Ribble Valley Borough Council  
Housing & Development Control

Application no: **3/2021/0963**

Address: **Tanner House Farm Higher Ramsgreave Road Ramsgreave BB1 9DJ**

Proposal: **Proposed two-storey and single-storey extensions to rear including balcony, and conversion and extension of garage to form granny annex including raised decking.**

Existing Detached Garage Layout Proposed Granny Annex Layout

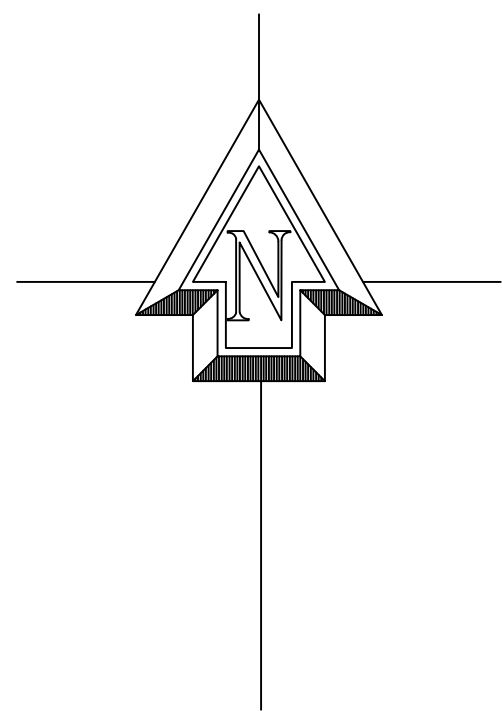
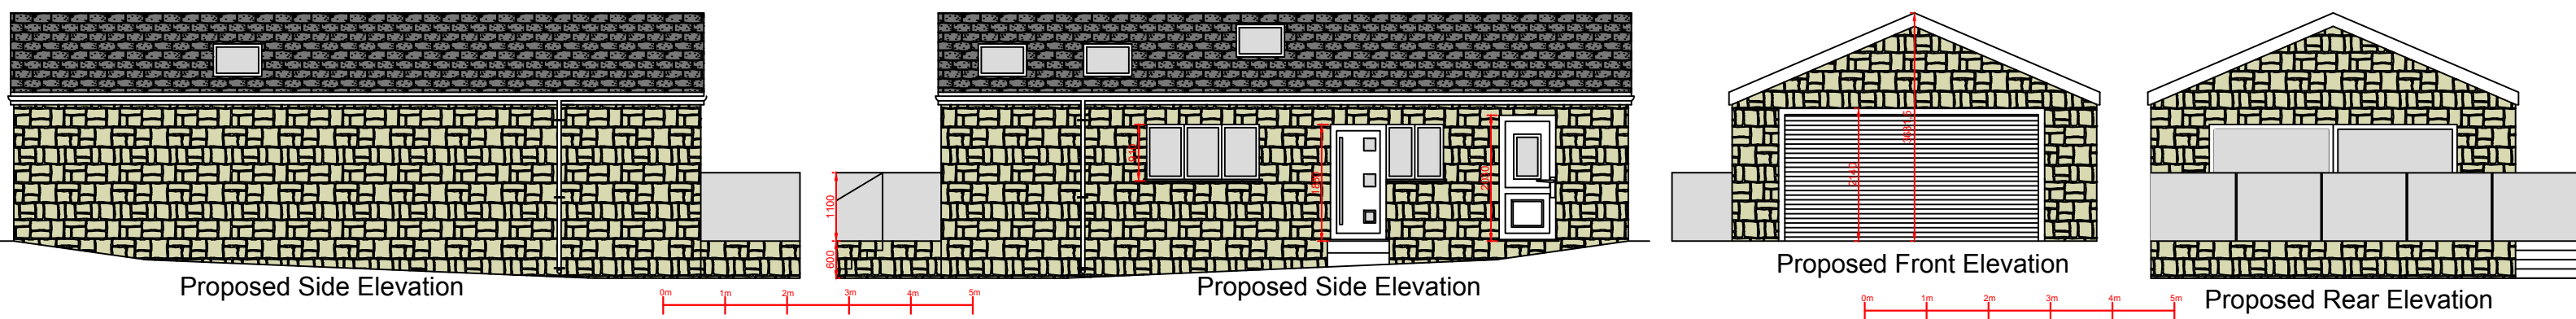
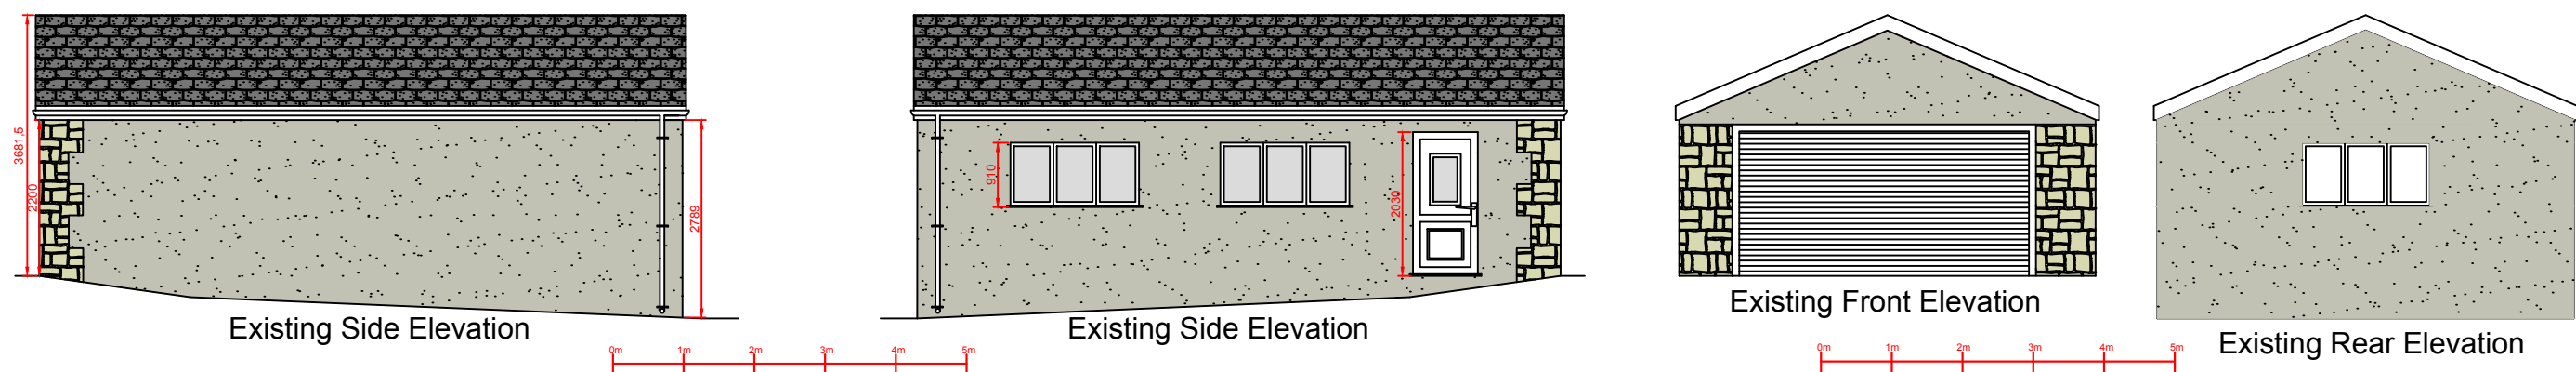
The number of bedrooms at the dwelling will also remain unaltered. However, the parking arrangements will change with the use of the garage now being the detached one bed annexe.

While the site will lose the garage for parking, there is adequate space on the driveway to provide the required 3 car parking spaces for a 4-bed dwelling and so the LHA have no comments to make.

The LHA also have no objection to the conversion of the garage into an annexe. However, the LHA will condition that the 1-bed annexe remains part of the existing dwelling and will not be used for commercial purposes without prior consent.

1. The annexe (detached building) hereby approved shall only be used ancillary to the enjoyment of the existing dwelling (household) and shall not be used by way of sale or sub-letting to form separate residential accommodation.
